A303 Amesbury to Berwick Down

**8.46 – Response to English Heritage objection to PRow to
Visitor Centre**

Response to English Heritage objection to PRow to Visitor Centre

Regulation Number:	Regulation 5(2)(q)
Planning Inspectorate Scheme Reference	TR010025
Application Document Reference	8.46
Author:	A303 Amesbury to Berwick Down Project Team, Highways England

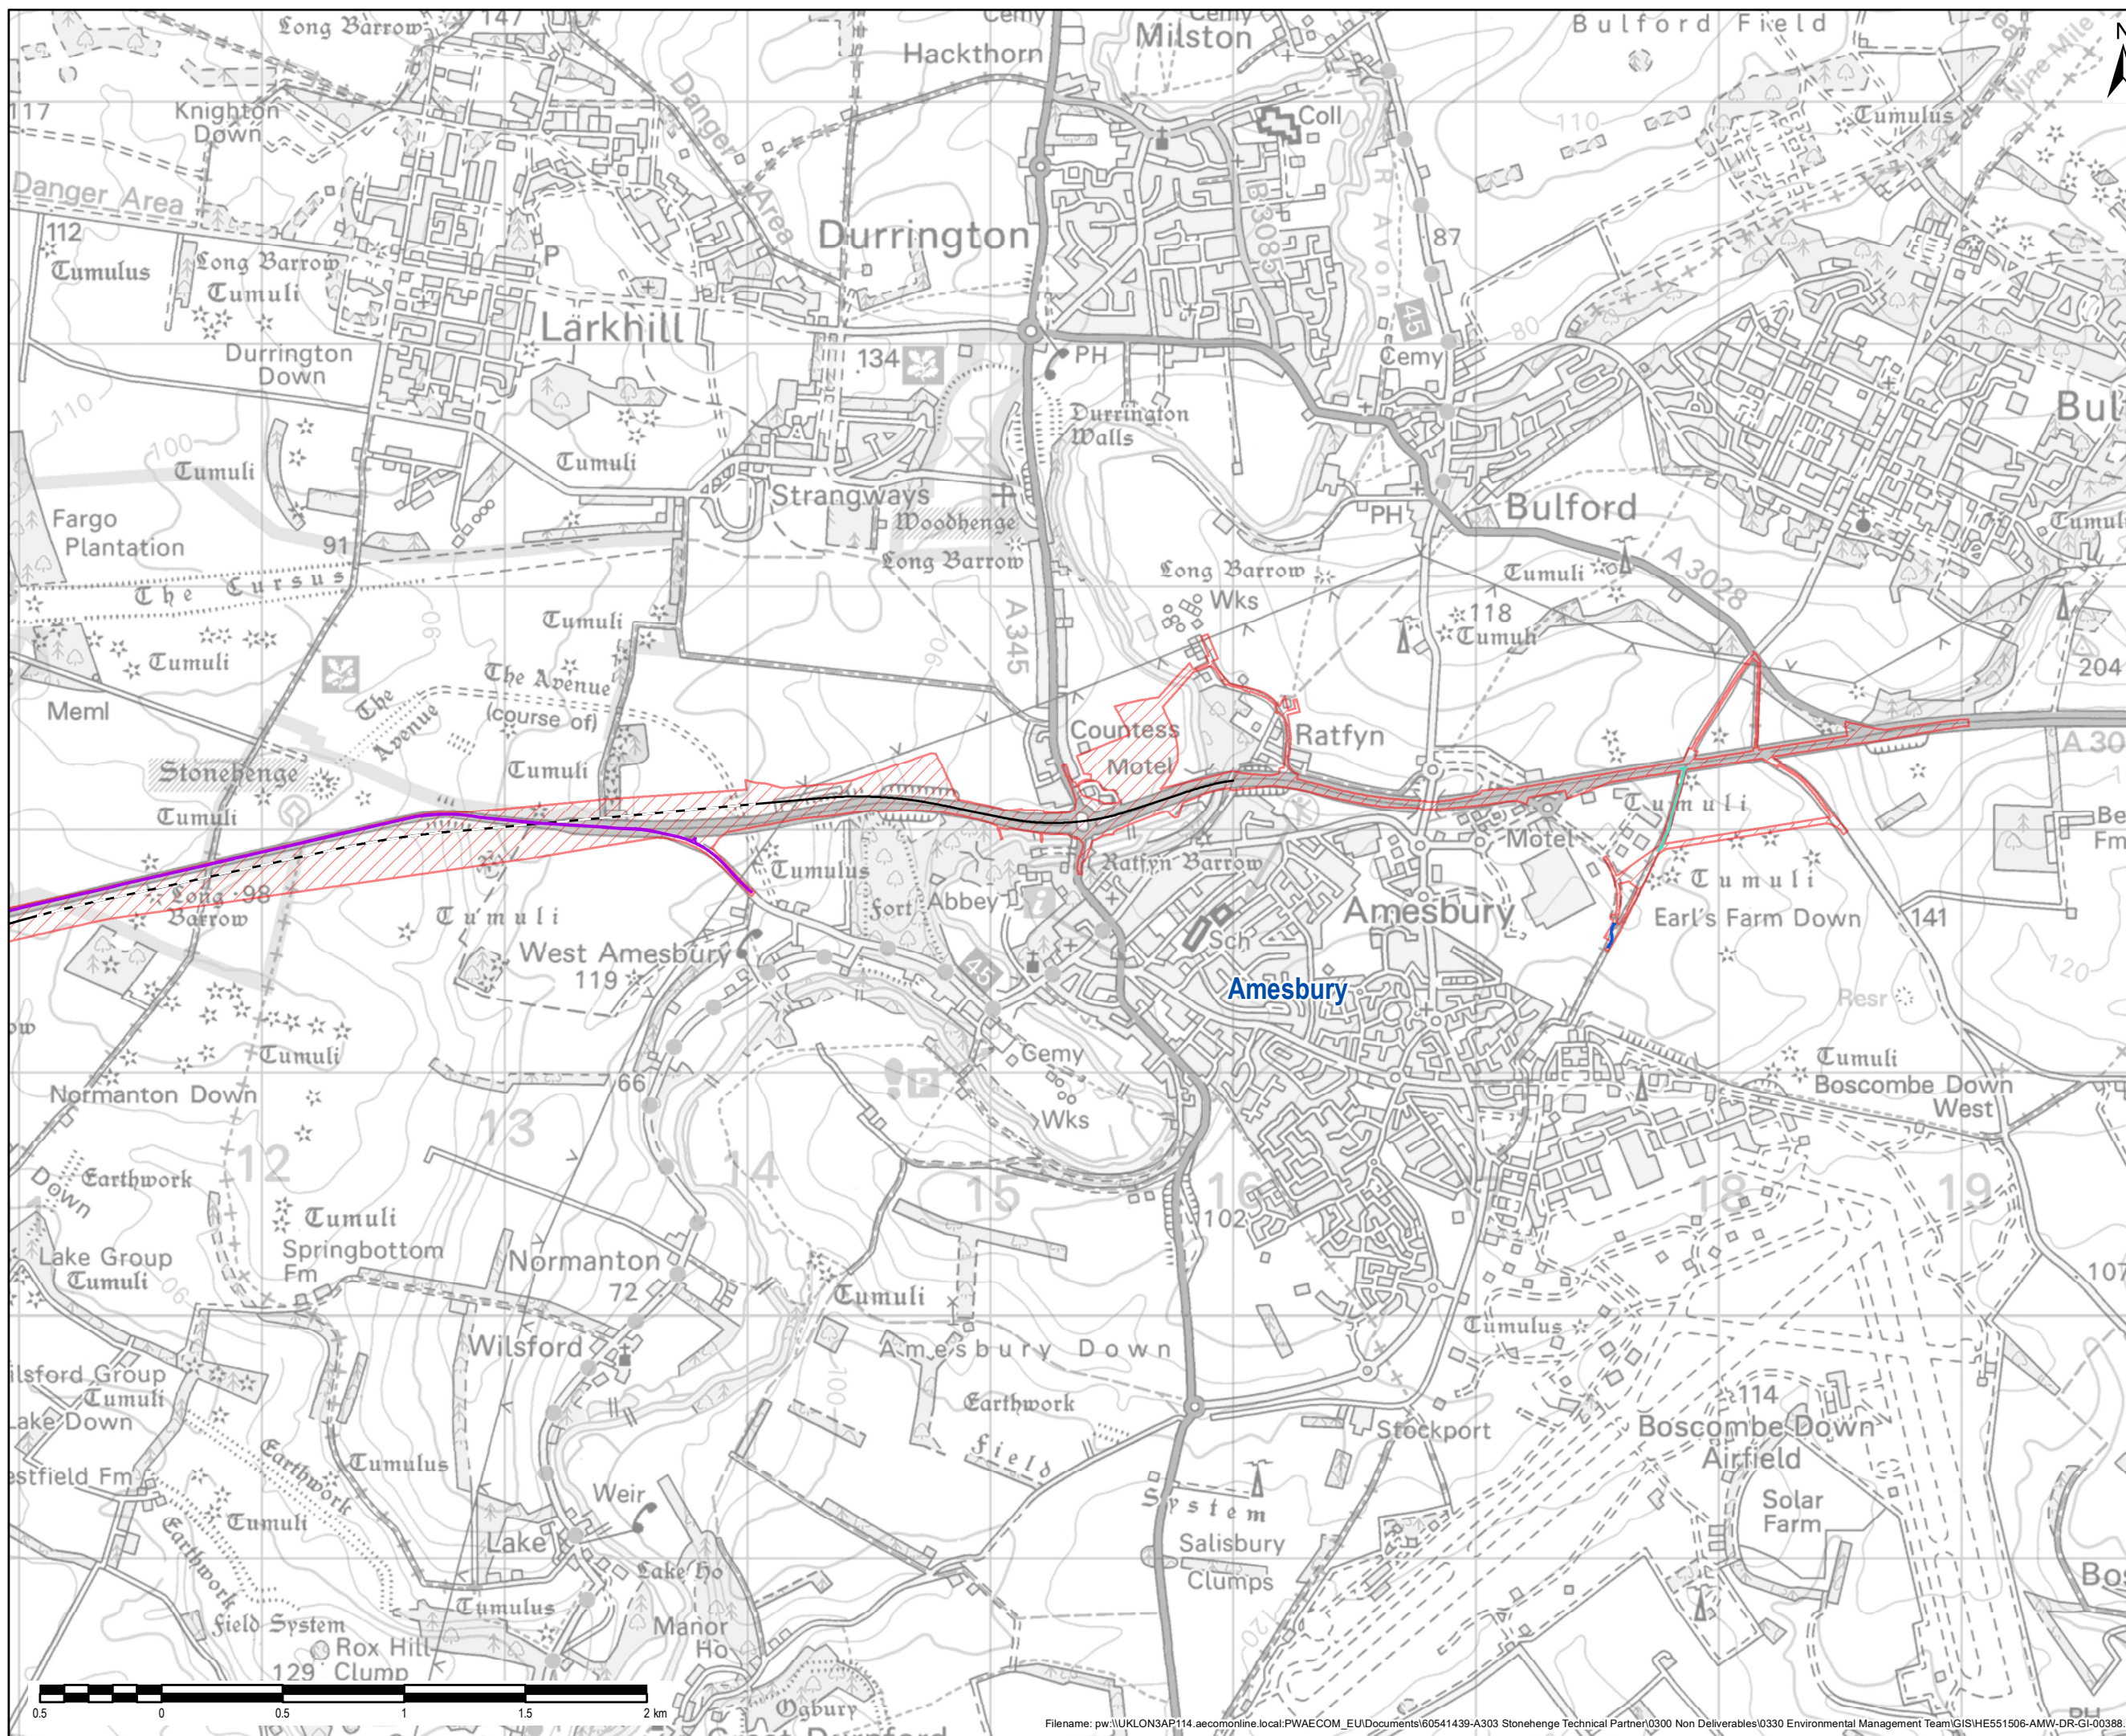
- 3.1.1 In its Written Representation [REP2-090], English Heritage Trust (EHT) objected to the Applicant's Scheme proposals (as outlined above – 'the proposed PRoW') on operational, safety, security and environmental grounds. In summary, EHT has stated that it objects to this proposal for the following reasons:

- Potential negative impact on English Heritage visitor operation
 - Potential conflict between non-motorised byway users and motorised vehicles
 - Potential negative knock-on impacts for A360/B3086 road users

- Potential safety risks
 - Negative impact on recent investment
 - Potential security risks
 - Negative impact on design principles
 - Heritage impacts
- 3.1.2 In Appendix 3 of its Written Representation [REP2-090], EHT provided a Public Right of Way Health and Safety Statement which identifies four potential hazards to members of the public using the proposed PRoW. In Appendix 2 to its Written Representation [REP2-092] EHT provided a Route Options Review, recording its assessment of the various options then under consideration as part of the Applicant's endeavours to propose a design solution acceptable to EHT.

- 2.1.1 As part of the A303 Scheme for which a DCO application has been submitted and accepted for examination, Highways England proposes a 4m wide restricted byway alignment on the eastern side of the A360, connecting into the local public rights of way network at the proposed Longbarrow junction to the south-west of the World Heritage Site, then running north-south, on an alignment lying to the east of the dew pond between the southbound carriageway of the A360 and the Visitor Centre, up to the Airman's Corner roundabout. The Scheme seeks to improve connectivity, enabling non-motorised users to access and explore the World Heritage site.
